## Jeanie Bourke - FW: Baxter Academy\_SFM letter\_Draft

**From:** Nancy Barba <nbarba@barbawheelock.com>  
**To:** "Richard.C.Nason@maine.gov" <Richard.C.Nason@maine.gov>  
**Date:** 8/17/2015 3:52 PM  
**Subject:** FW: Baxter Academy\_SFM letter\_Draft  
**CC:** "carl.stasio@baxter-academy.org" <carl.stasio@baxter-academy.org>, "Jean...  
**Attachments:** A001\_CODE STUDY PLAN.pdf; 2015\_0722\_Code Study\_561 Congress.pdf

I am following up on our meeting last week to review the drawings for Baxter Academy of Arts and Technology with you at the State Fire Marshal's office and the results of some of your change requests.

CODE STUDY, 561 CONGRESS
 FIRST FLOOR LIFE SAFETY PLAN

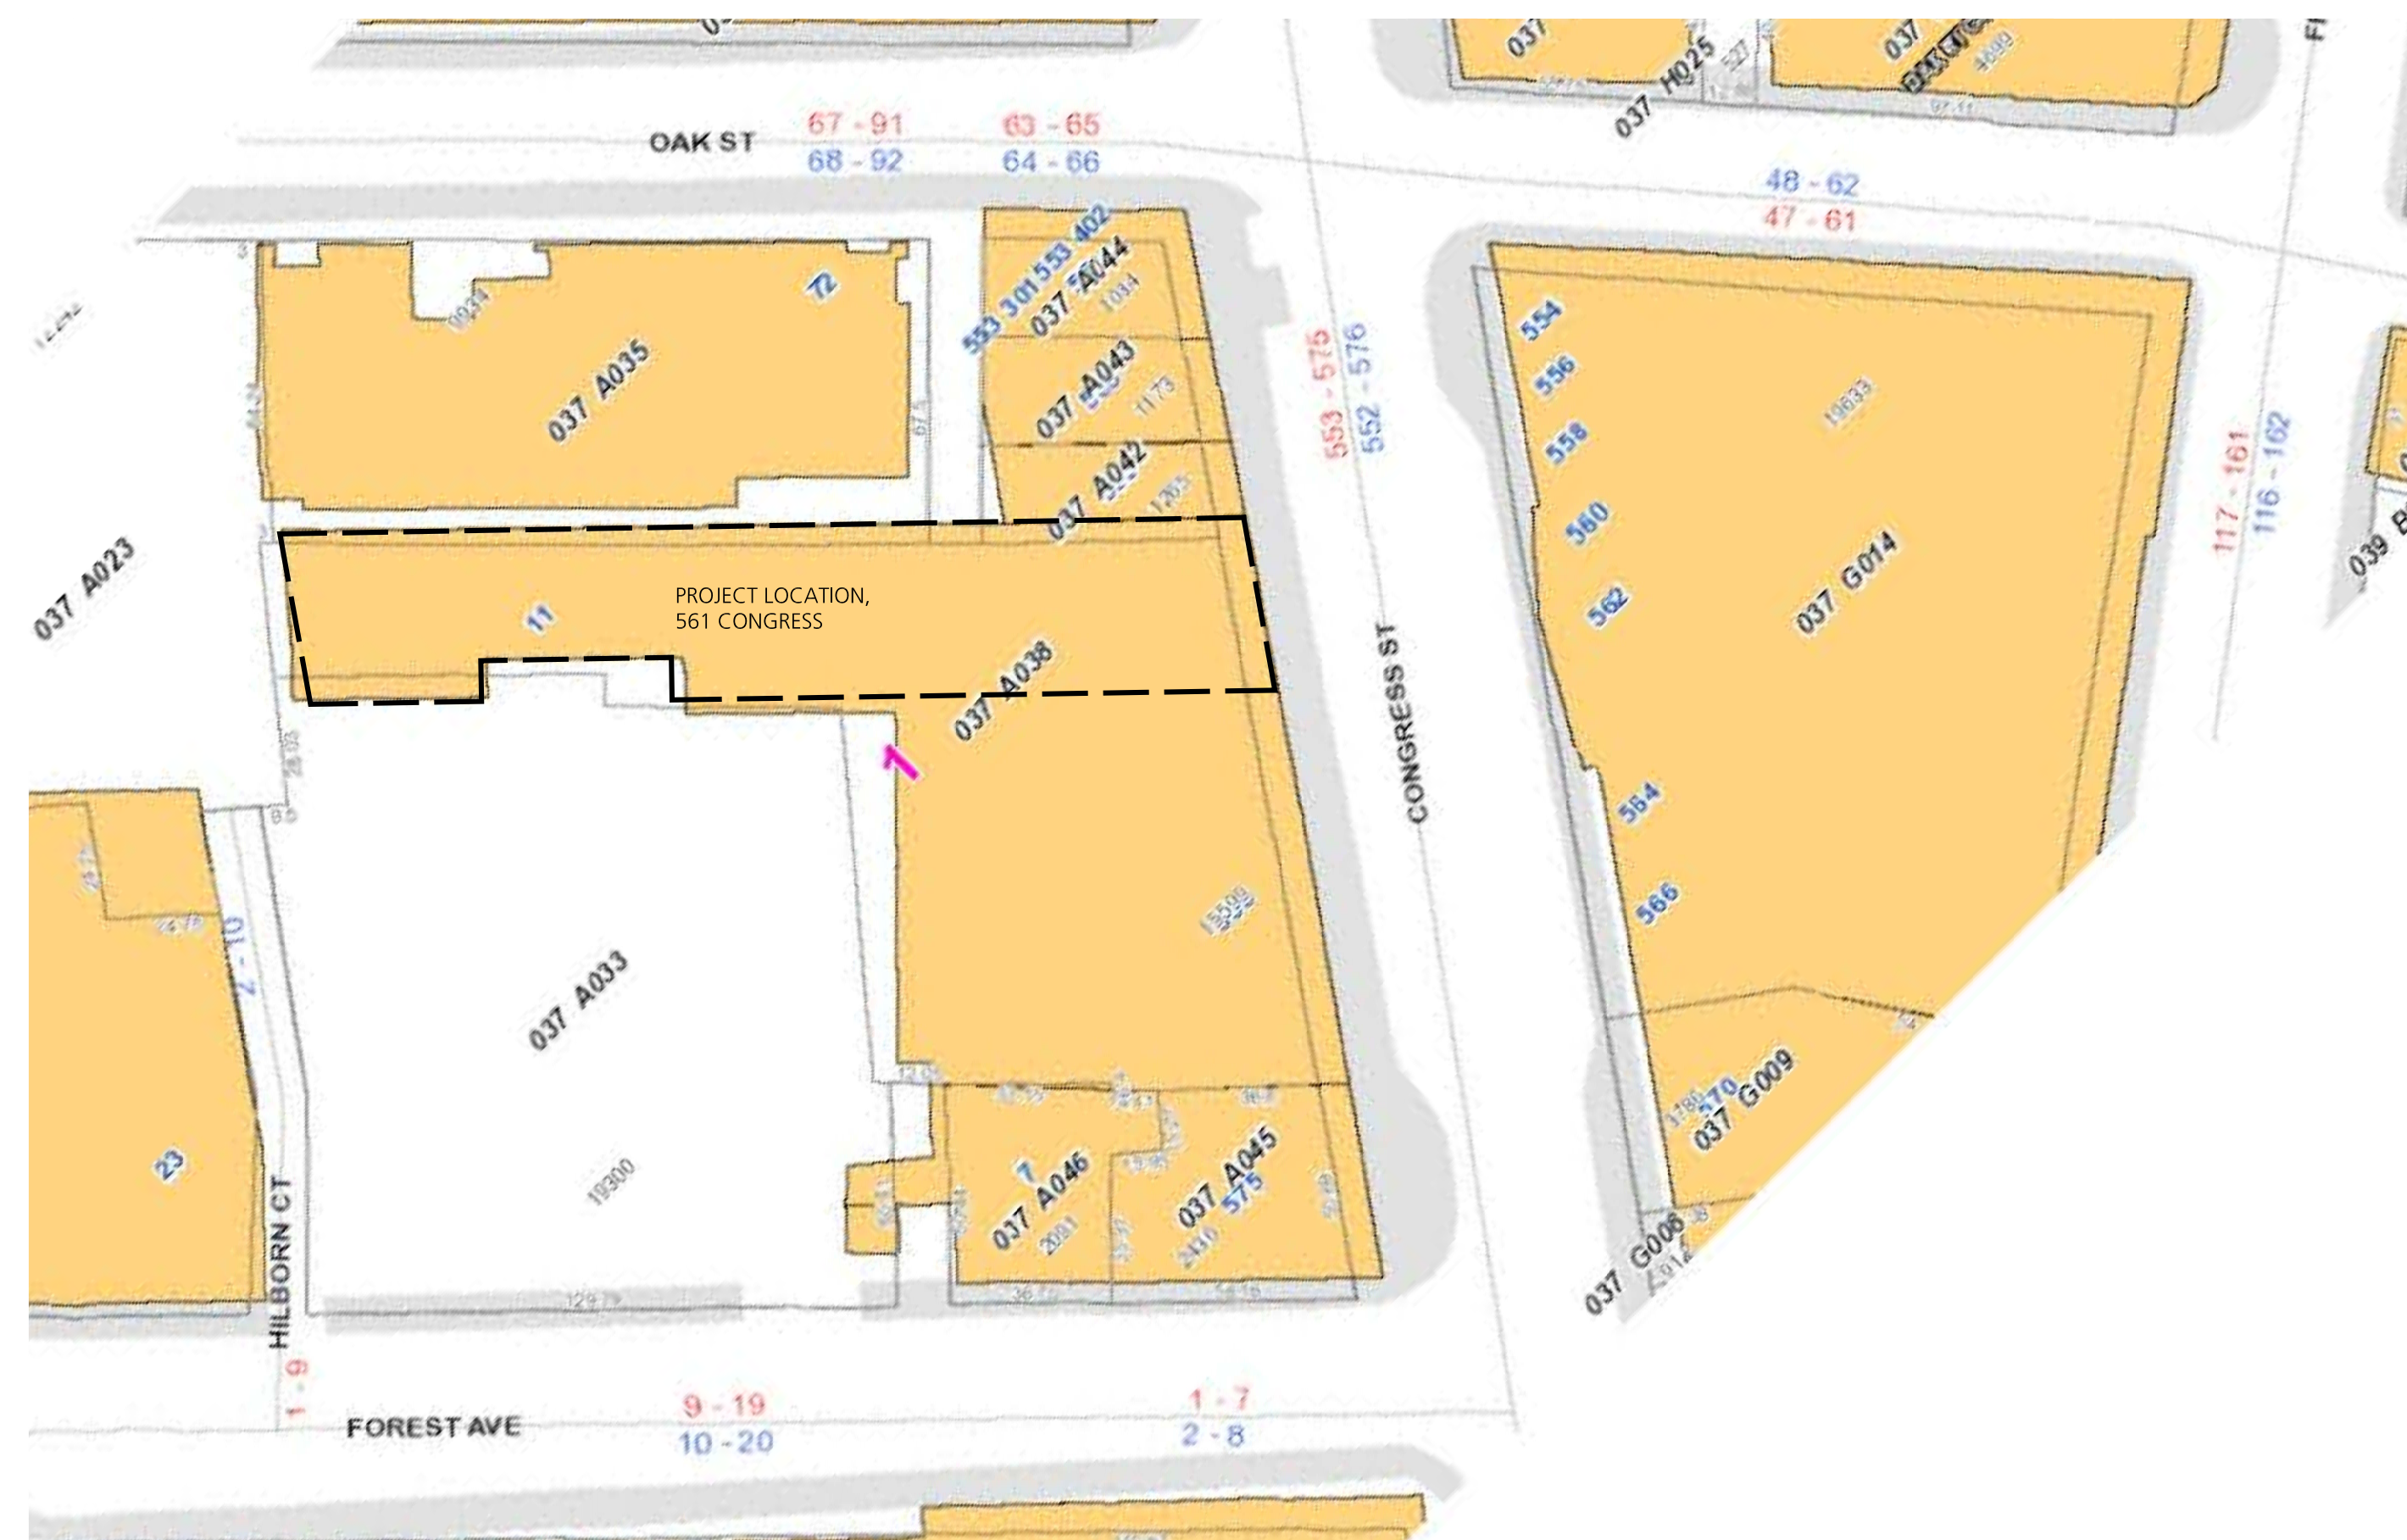
- Although IBC allows Educational use to have corridors as narrow as 44 inches in width if there are fewer than 100 students, in NFPA has no exceptions to the 6 foot corridor width.

- As the use has limited occupancy (less than 100 students in the classroom area) you were willing to consider this temporary use and allow the corridor width to remain for the duration of their three-year lease as long as you could reach agreement with the Owner about their milestone dates for achieving their master plan build out to create space under one roof. Should the Owner miss their milestones you would require them to immediately proceed with renovations to correct the width to 6 feet. *A letter will follow to you this week for your review and final determination.*

- You would like to see a direct exit from Classroom 21 to the outside. If not, this remote Classroom could be used for administrative in lieu of classroom space. *We have discovered that a direct exit at one of the windows poses problems to achieve. Both directions require other property owner concurrence, more extensive construction, and likely legal easements. We are proposing, instead, that with minor renovations, the corridor wall at Office 22 can be relocated and the Office reallocated as Storage 22 to allow a 6-foot corridor width at this location. The attached plan shows this proposed configuration.*

- In terms of the 2 hour separation of walls, there is one "indentation" shown on the floor plan directly adjacent to the Dark Room 29. The remainder of the wall is concealed but based on the thickness and period of construction we can feel comfortable that this wall is a 2-hour masonry wall. We need to confirm that the "indentation" on the plans rating between the Assembly use of the adjacent Restaurant and Baxter Academy can meet the 2-hour rating. Contrary to the Owner's Architect's comment in their letter, there does need to be a rating between an Educational and Assembly use. You clarified that the code that they might be referring to covers Assembly use within an Educational setting, such as a school gymnasium. *From an on-site review there is a sealed exterior door with 10 x 10*

*vision panel in this location. A steel stud wall with drywall facing the interior of this space closes off this unused door, and is evident through the window view. My recommendation will be to replace the fire door with a 90-minute solid fire door as it is directly across the l-corner, adjacent to the door with vision panel that serves the restaurant. See the attached plan.*
